Recommendation Report for Planning Permission for Works or Extension to a Dwelling

REF NO: BR/59/20/HH

LOCATION: 4 Lansdowne House
The Esplanade
Bognor Regis
PO21 1TR

PROPOSAL: New second floor balcony and inward opening French doors.(This application may affect the setting of The Steyne Conservation Area)

PROPOSED SECOND FLOOR PLAN

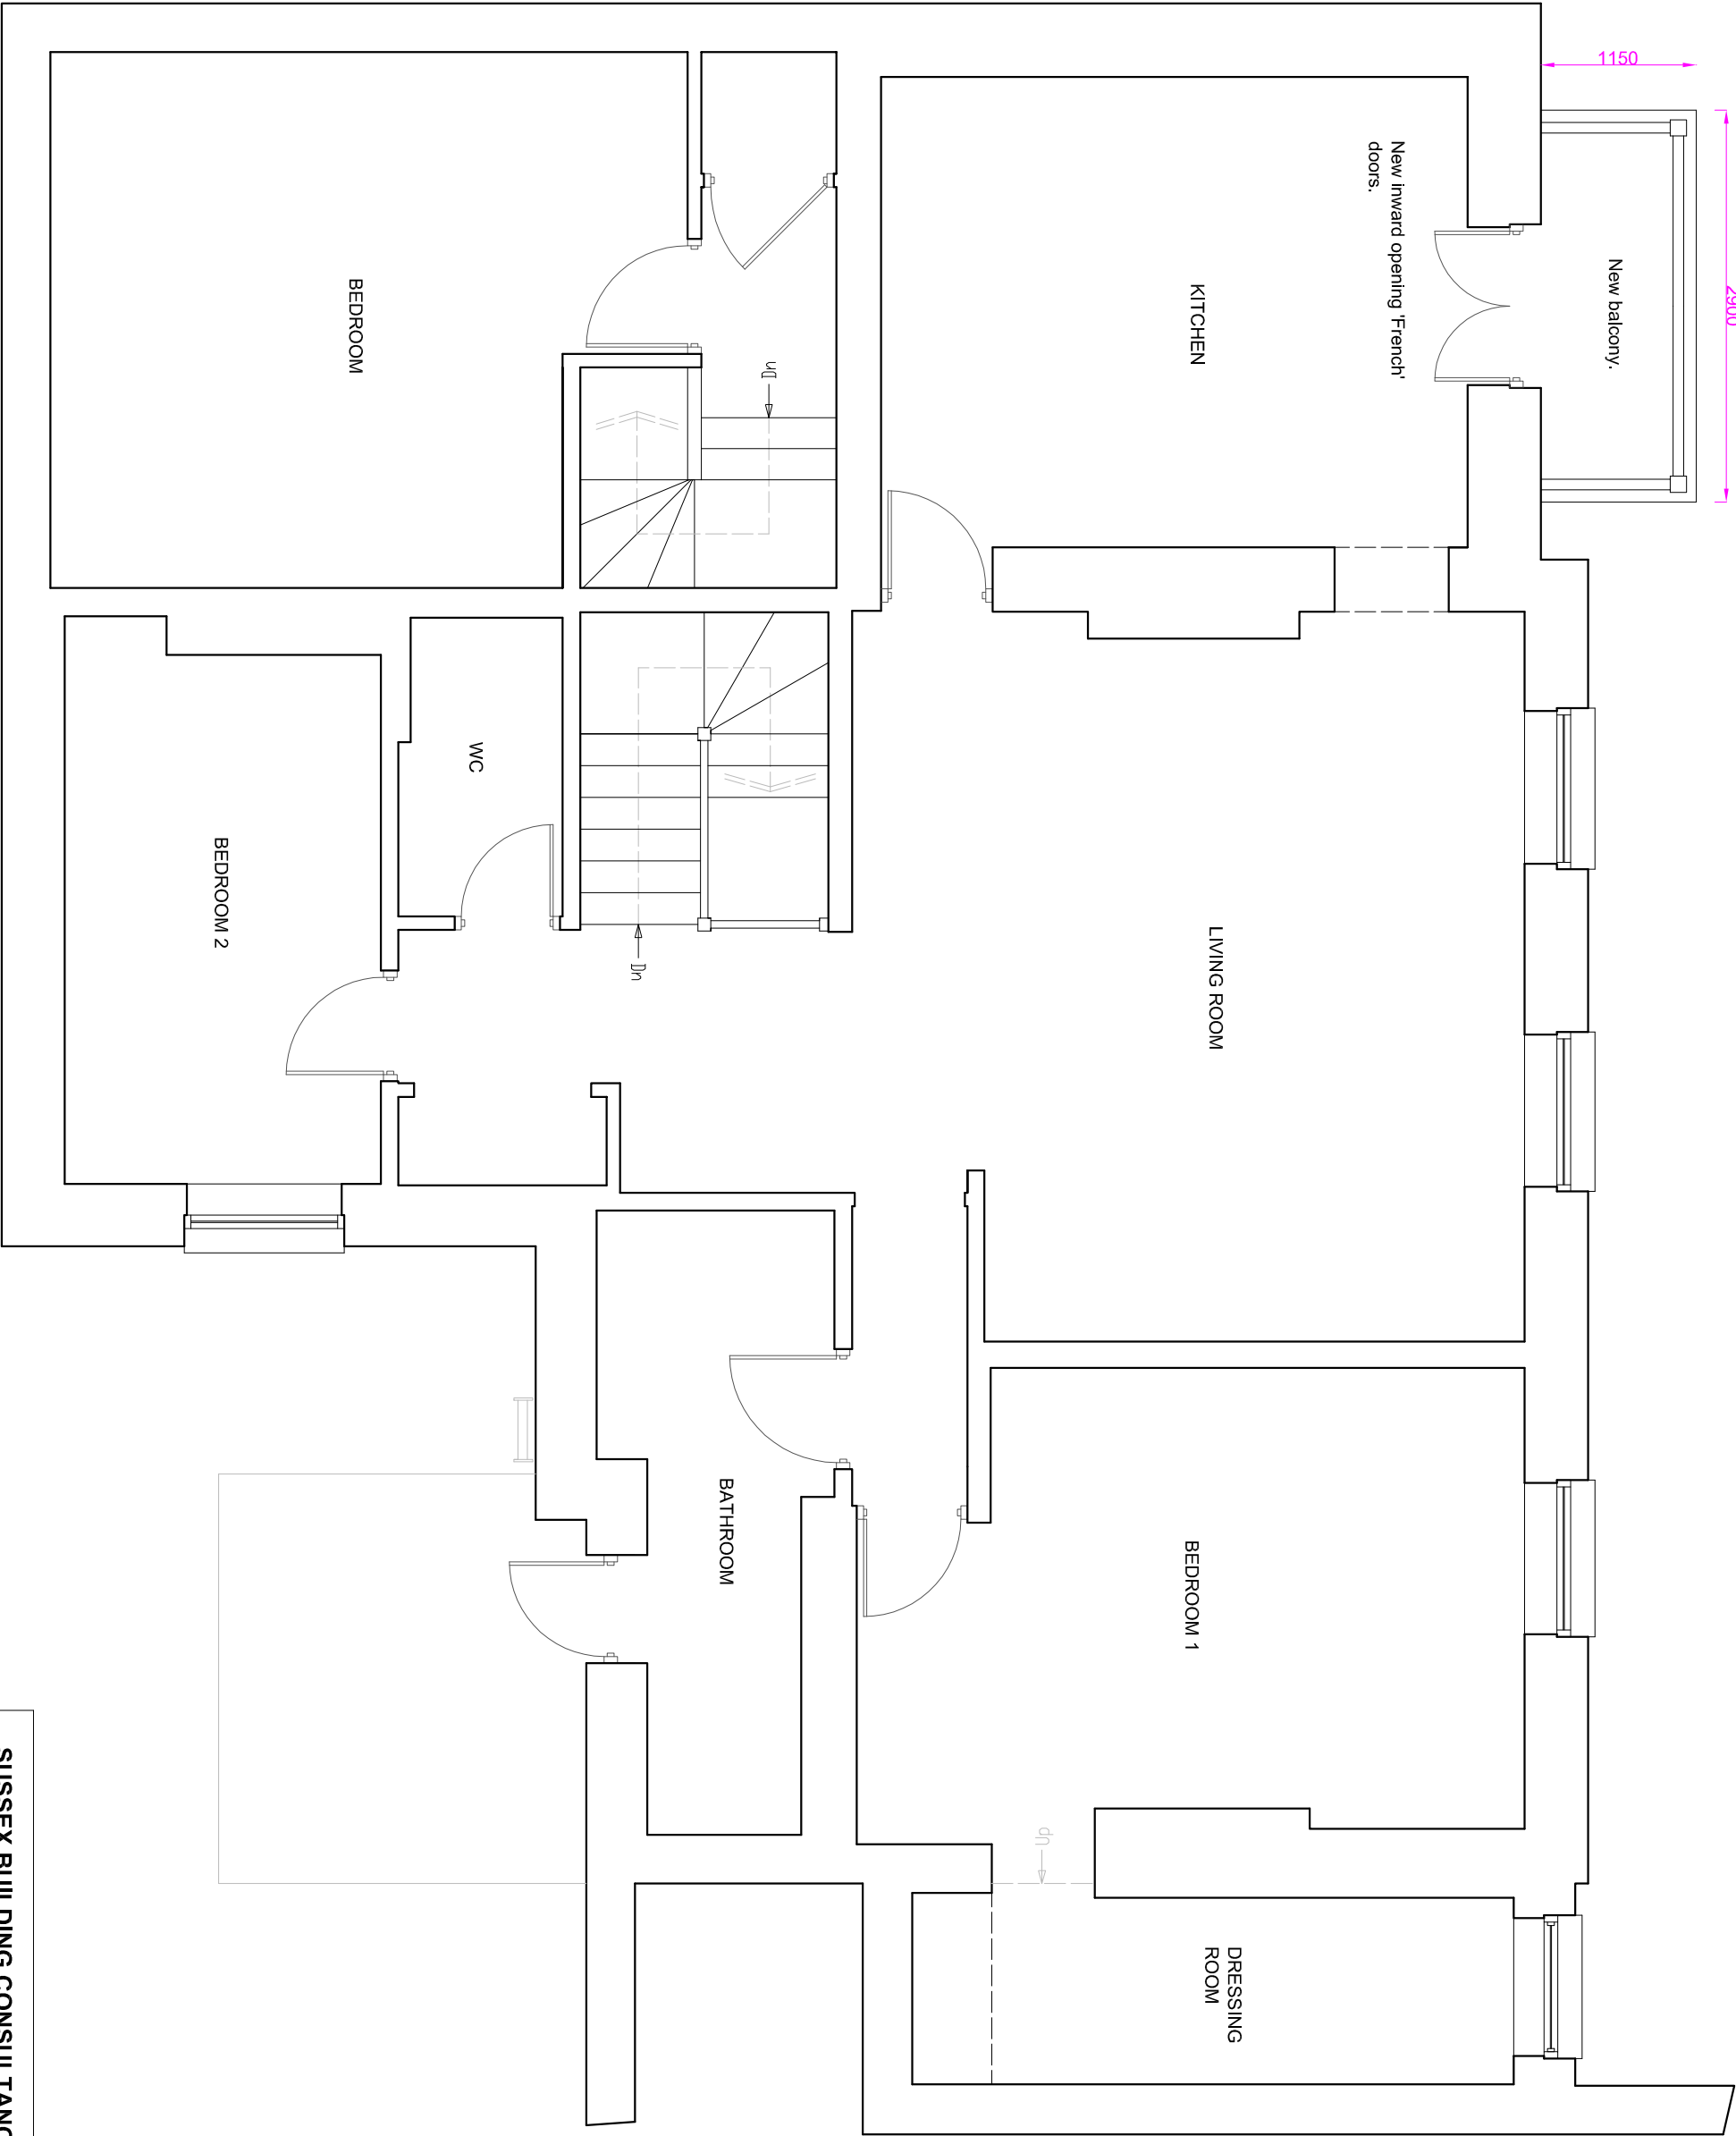
The building has 3 storeys with the ground floor forming a restaurant. At first floor there is a balcony to one of the flats. The proposal seeks to replace an existing 2nd floor window with a balcony similar to that below. This will remove a small part of the bay window roof from the storey below.

Due to the scale and type of the development it is not considered to appear overbearing or overshadowing. The balcony replaces a window and with views facing south over the street scene and beach it is not considered to result in adverse overlooking.

PROPOSED ELEVATIONS

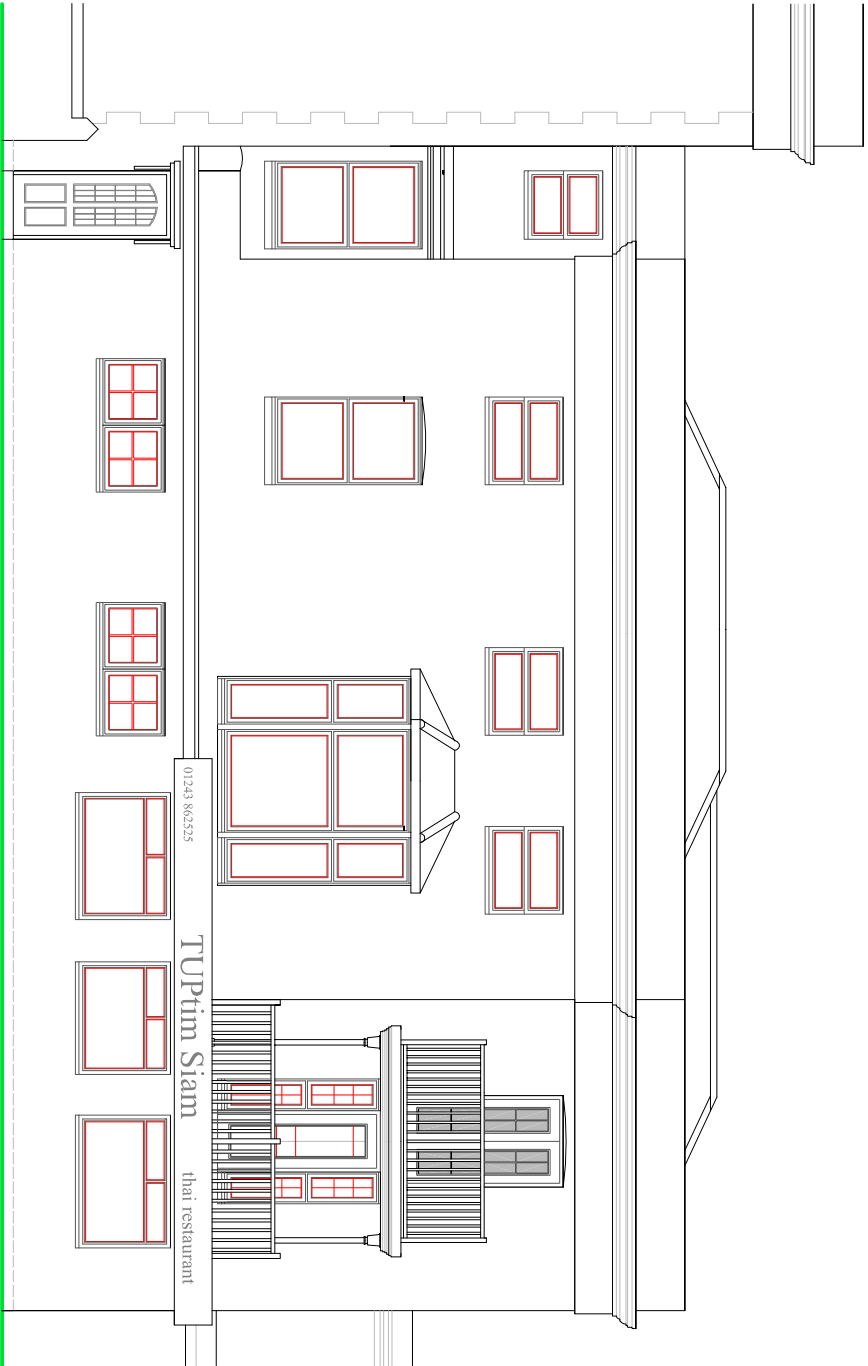
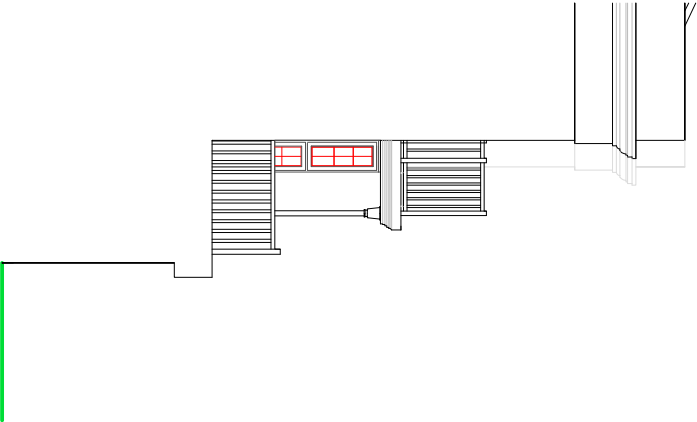
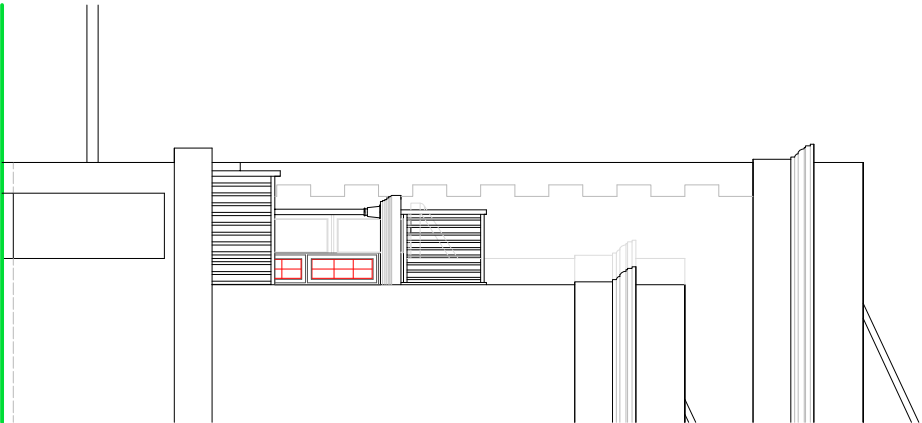
The balcony is well integrated with the building, similar in design to that of the balcony below, although slightly smaller in depth and width and as such is not considered to appear overly dominant.

The first floor windows are larger than those on the second floor. The second-floor windows, whilst all appearing to be modern replacements have not affected/alterd the original openings themselves; i.e. dimensions and locations. The proposed balcony and associated French windows are problematic in that they directly affect the appearance of the upper section of the building. Introducing French Windows results in the loss of the original openings and disturbs the fenestration on this part of the building.
